Application no: H02-0496-11

Location: Martins Farm
Postland
Crowland
Peterborough
PE6 0JU
PE6 0JU

Amendment: Amended design details (dwg. nos. 300-07-16, -02B, -03A, -04B, -05B, -08A, -09B, -12B, -15A)

Re: Martin's Farm, Postland, Crowland – Your Ref: H02-0496-11 – Conversion of barns into two residential dwellings

AMENDED PLAN
Ref. A1

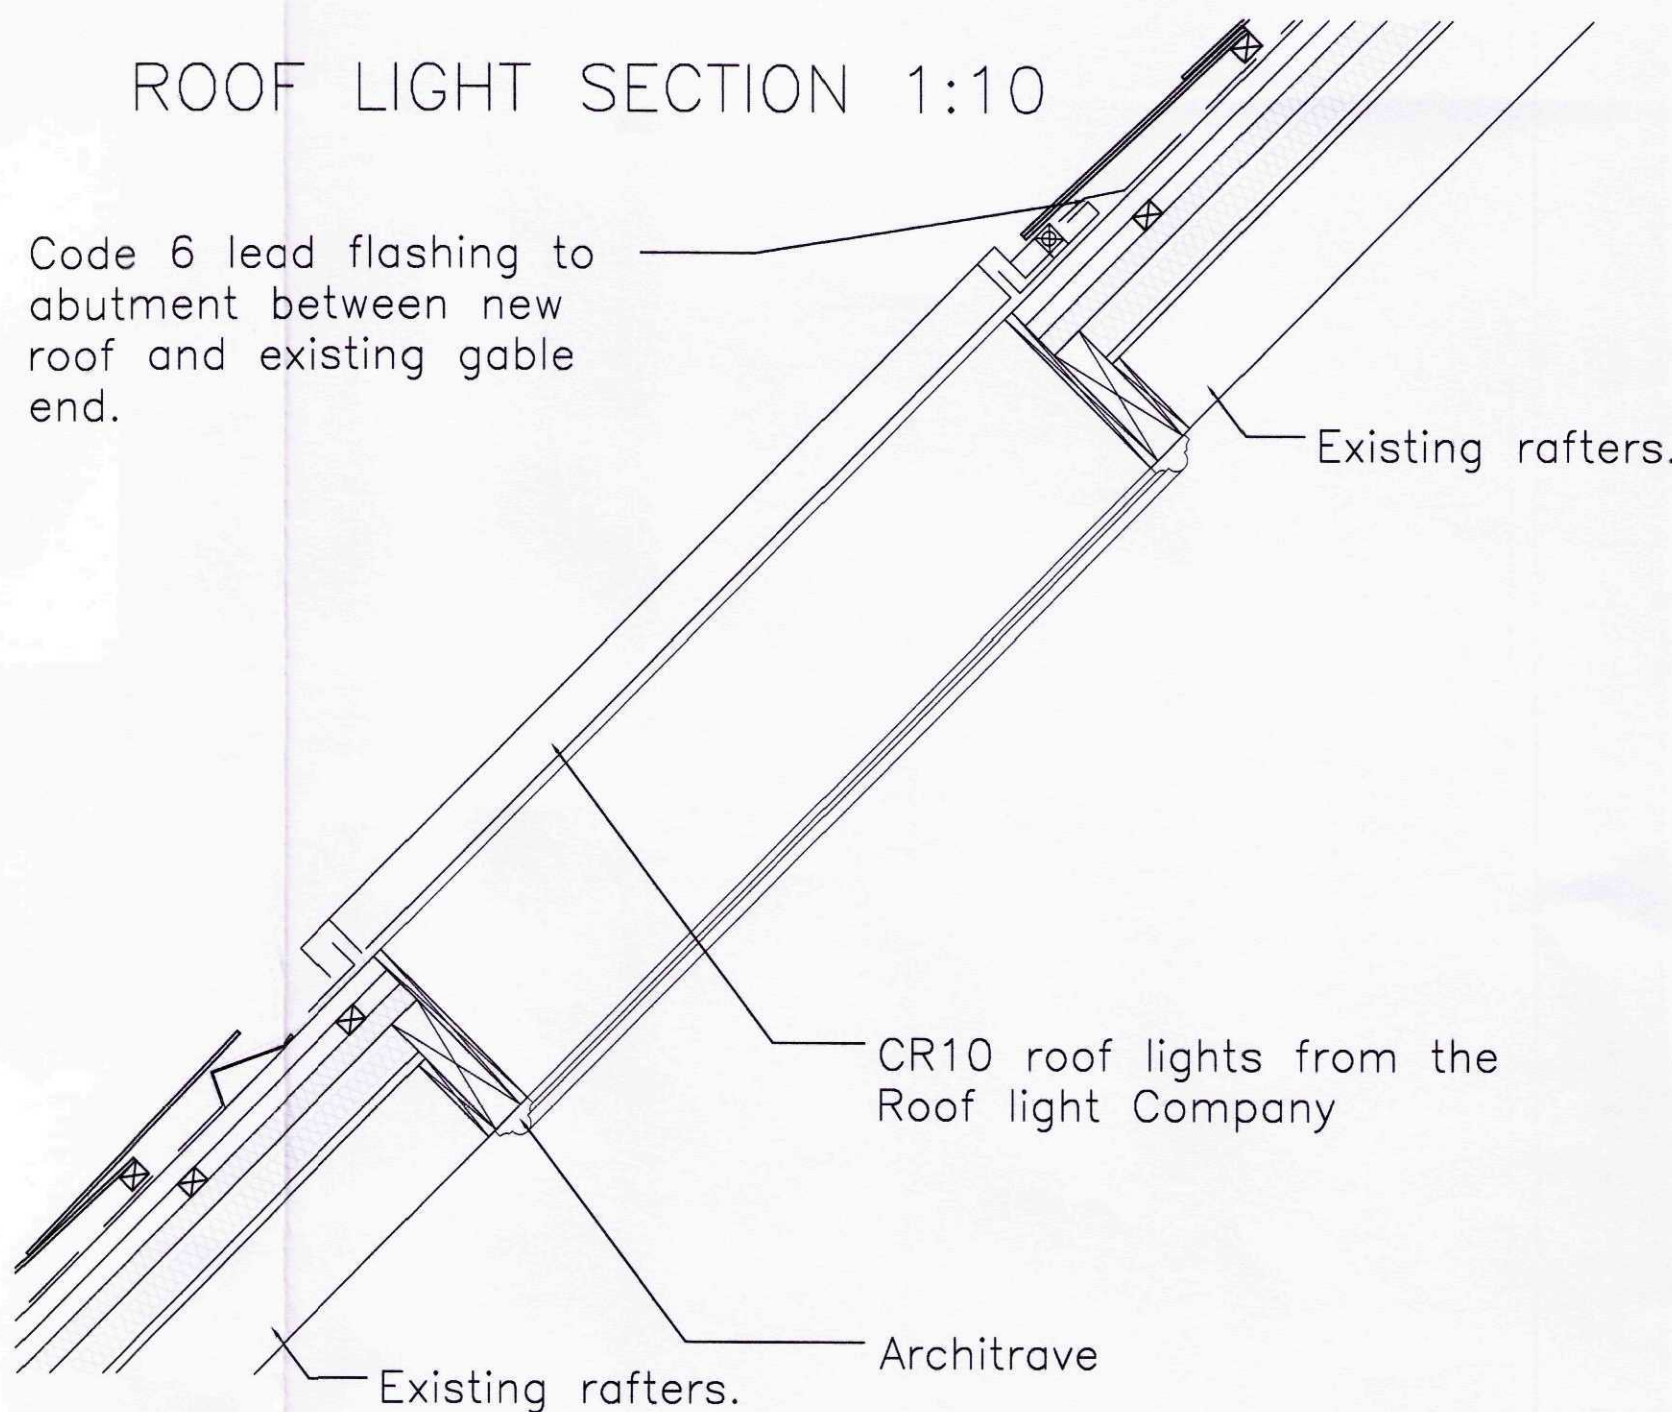
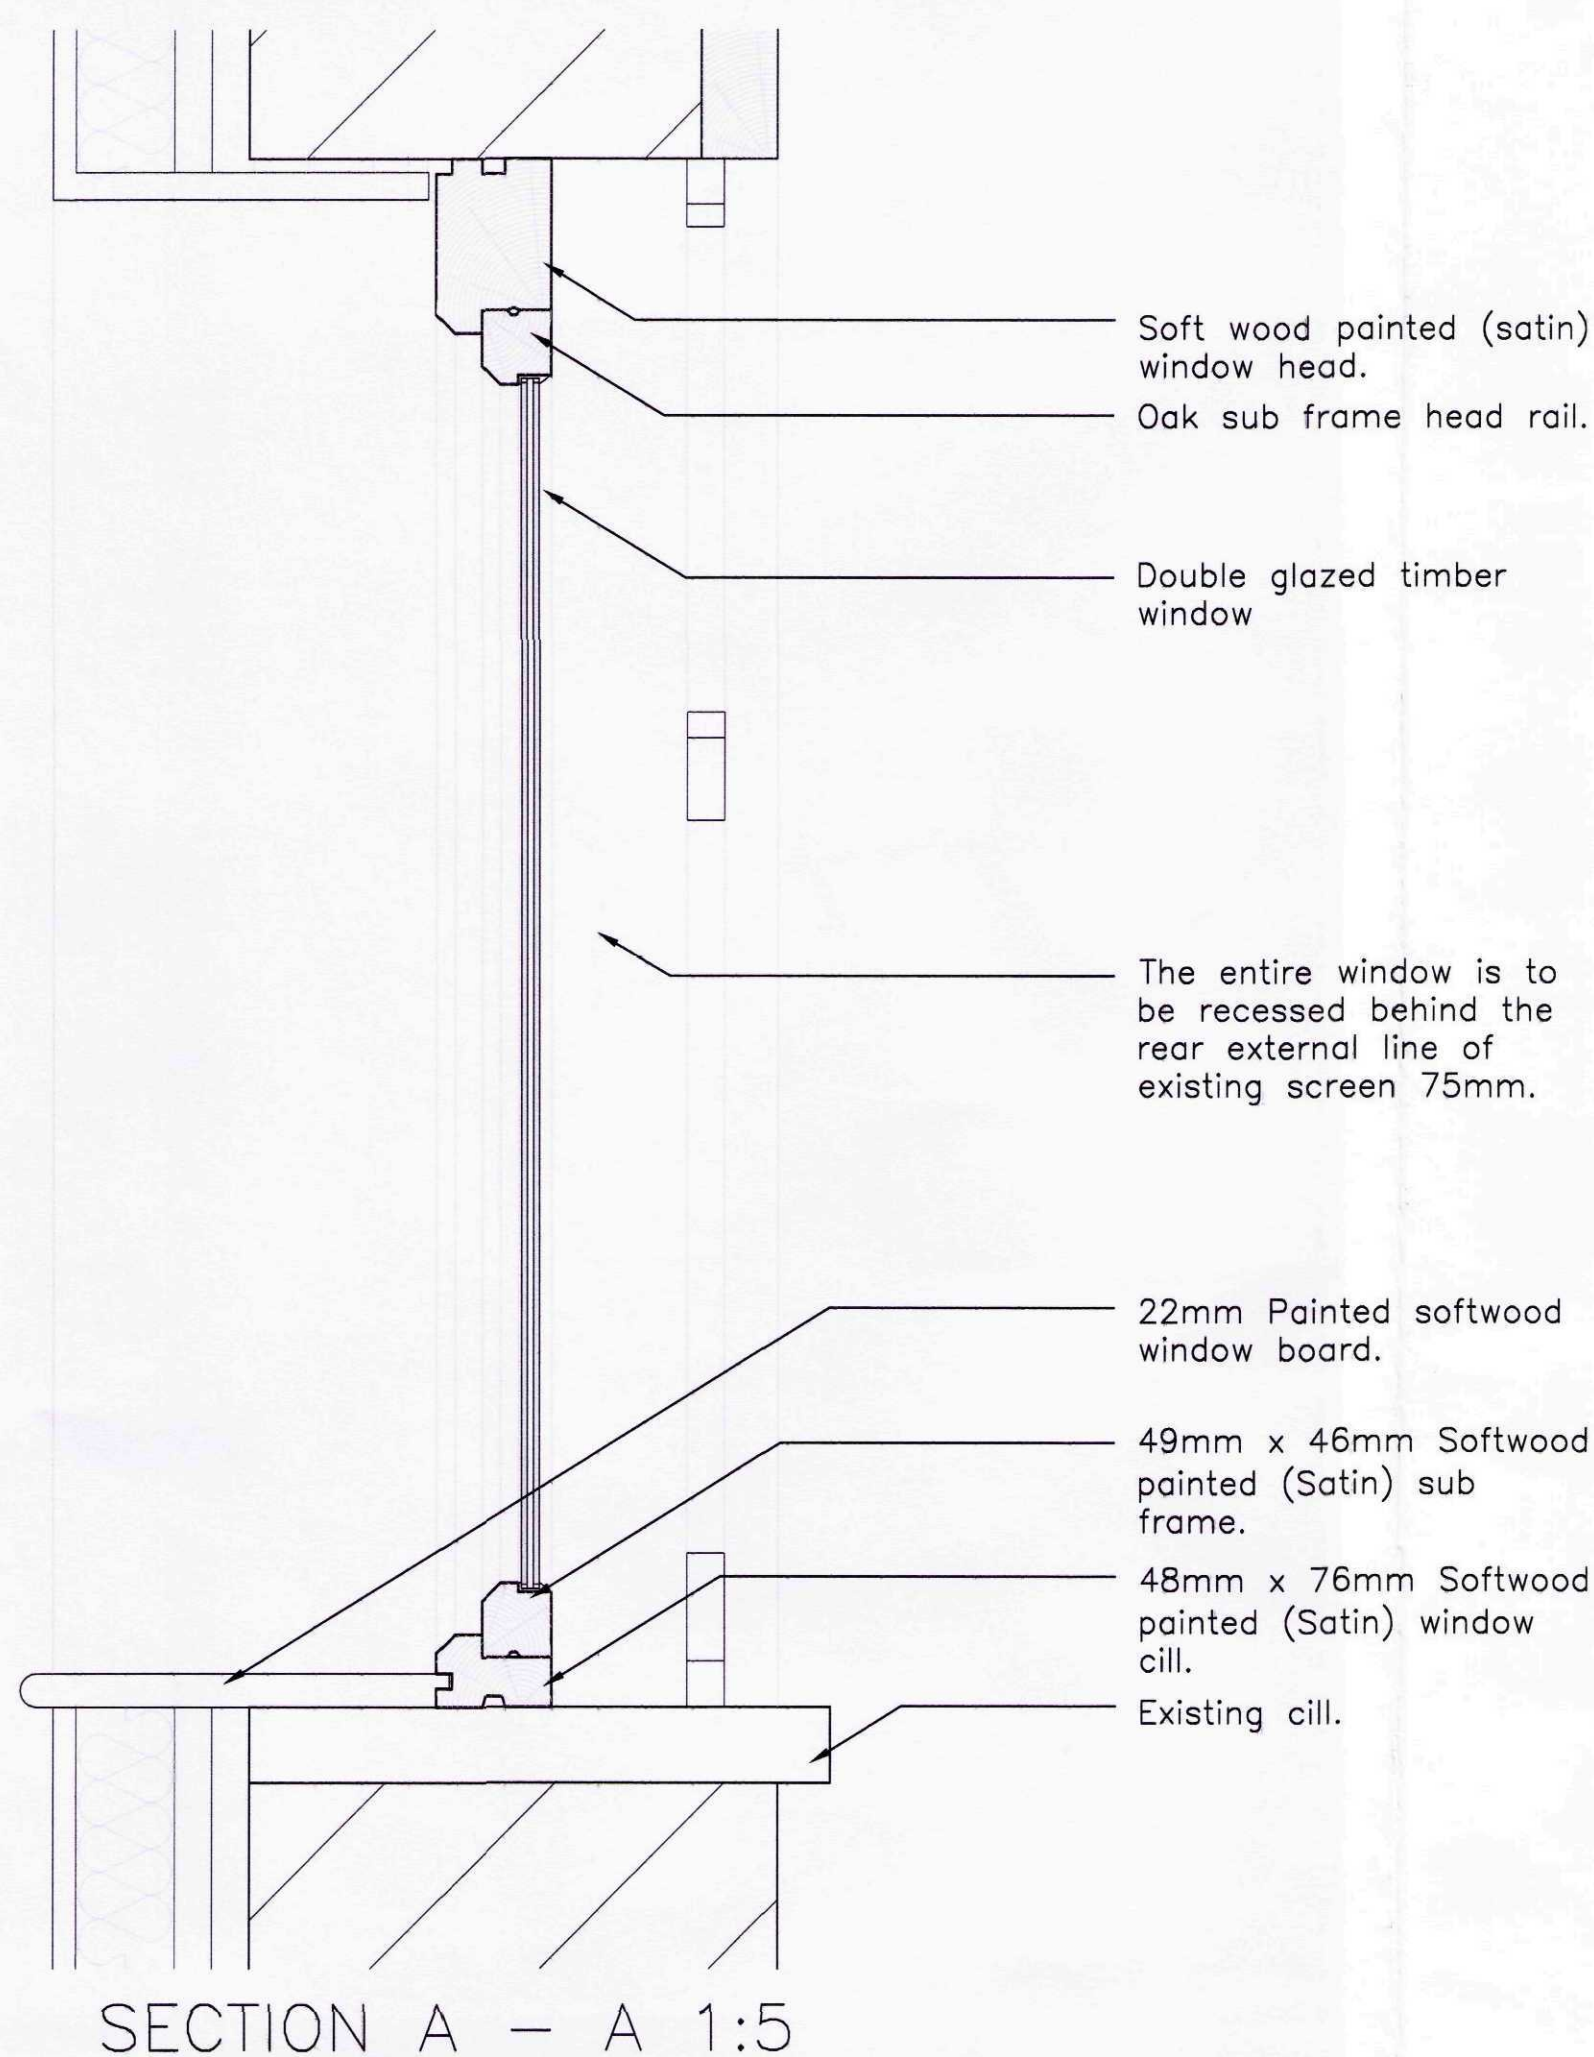
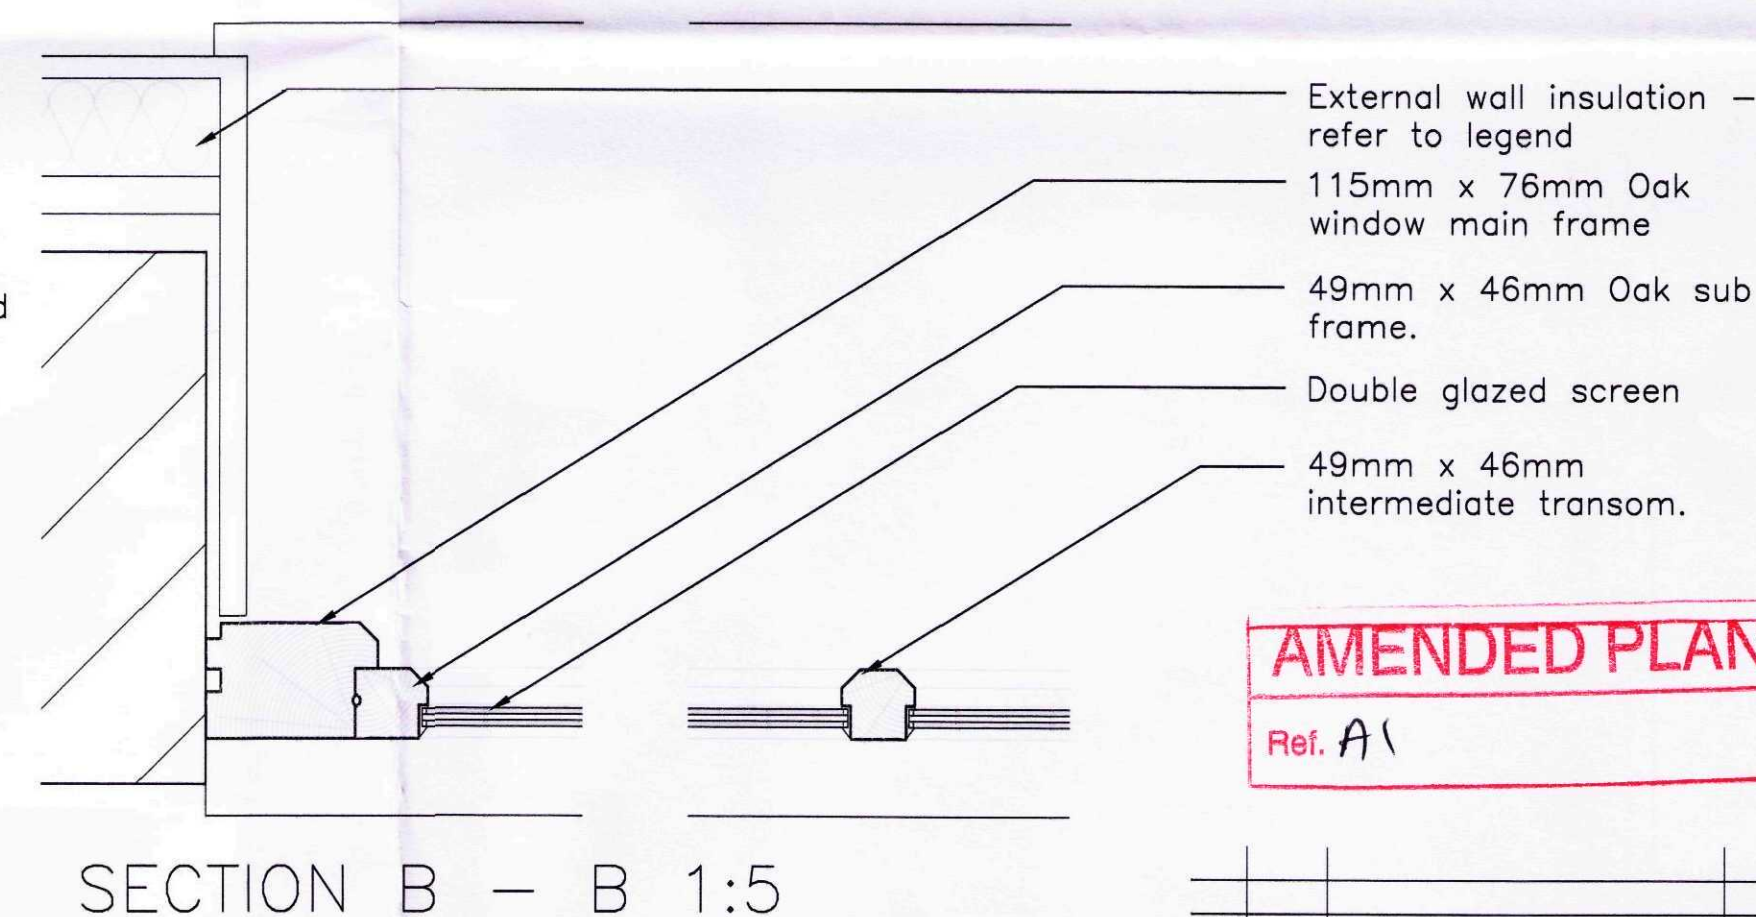
With regard to the windows, please refer to the enclosed revised plans and detail drawings.
